REFUSAL OF PLANNING PERMISSION

APPLICATION NO. 2026/0102

Proposal Erection of front and side boundary wall 1m to 1.5m in height (Retrospective).

At 11 Hardwick Grove, Dodworth, Barnsley, S75 3SS

Drawing Title **SITE PLANS**

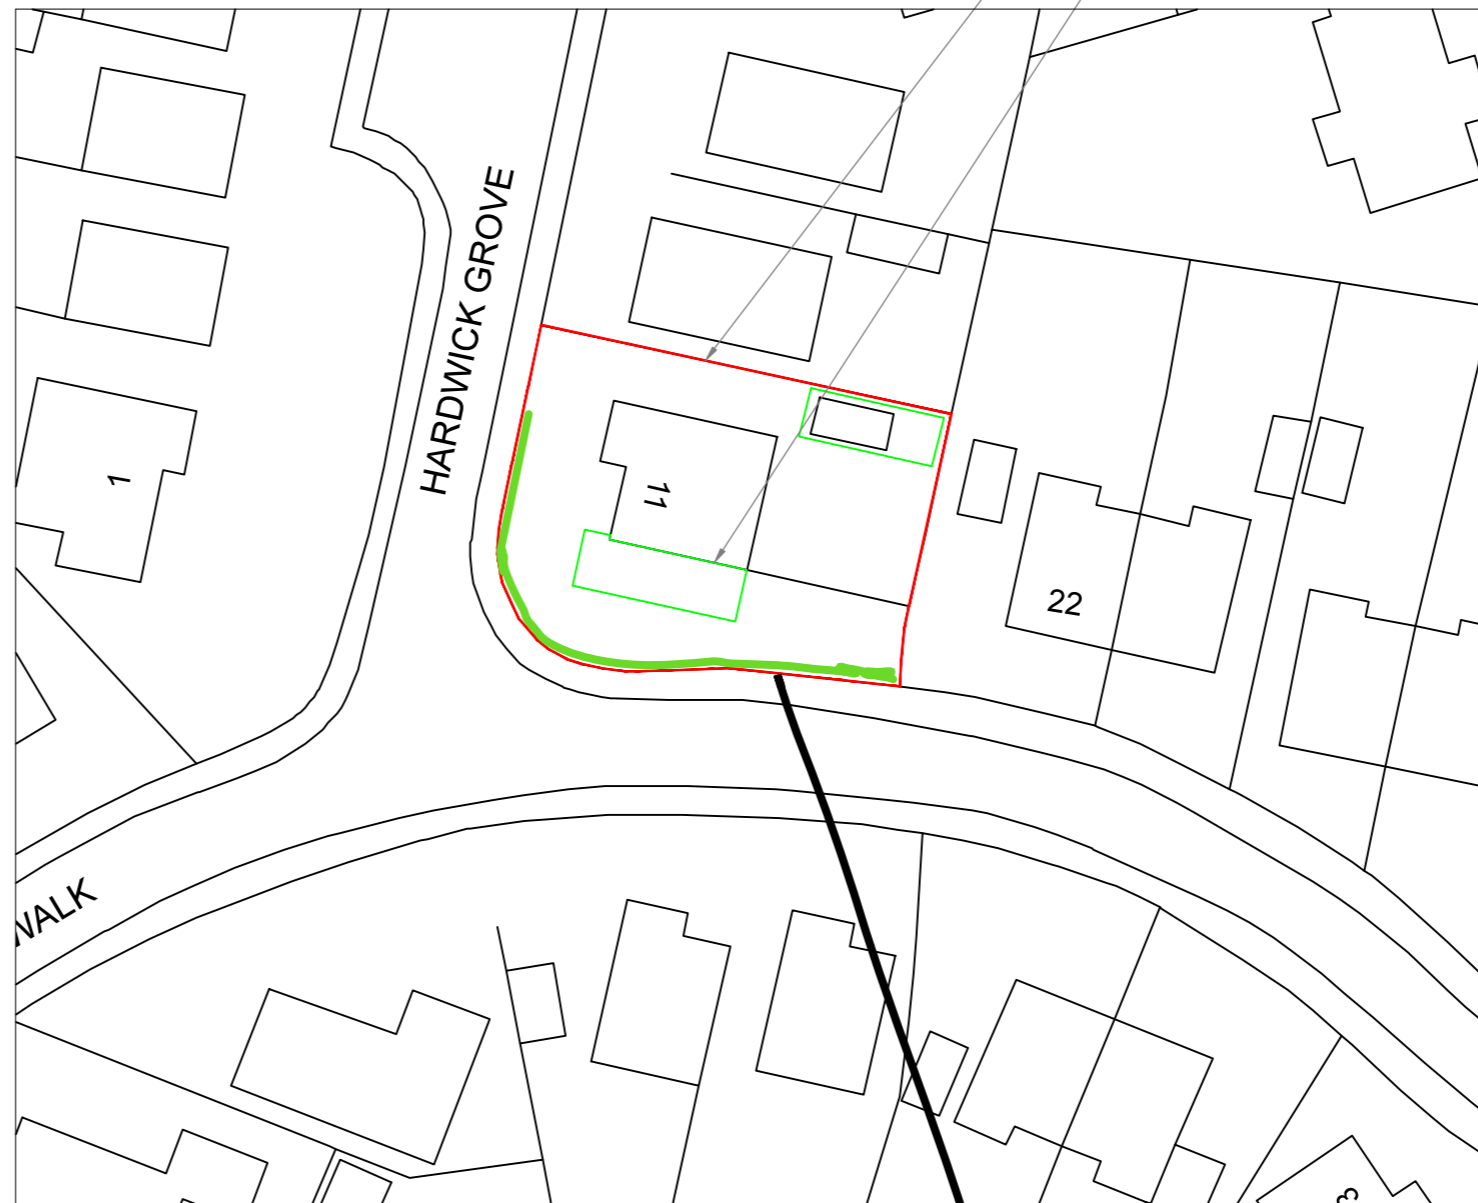
- 1 In the opinion of the local planning authority, the wall is located in a prominent location and is considered to be of a height, scale and dominance which is out of character with the area and street scene and contrary to the Walls and Fences SPD. Consequently, this application is considered to be contrary to Local Plan Policies GD1: General Development and D1: High Quality Design and Place Making.
- 2 Insufficient information and clarification has been provided in order to determine if the proposal is acceptable in terms of its impact on highway safety and in compliance with Local Plan Policy T4 New Development and Transport Safety.
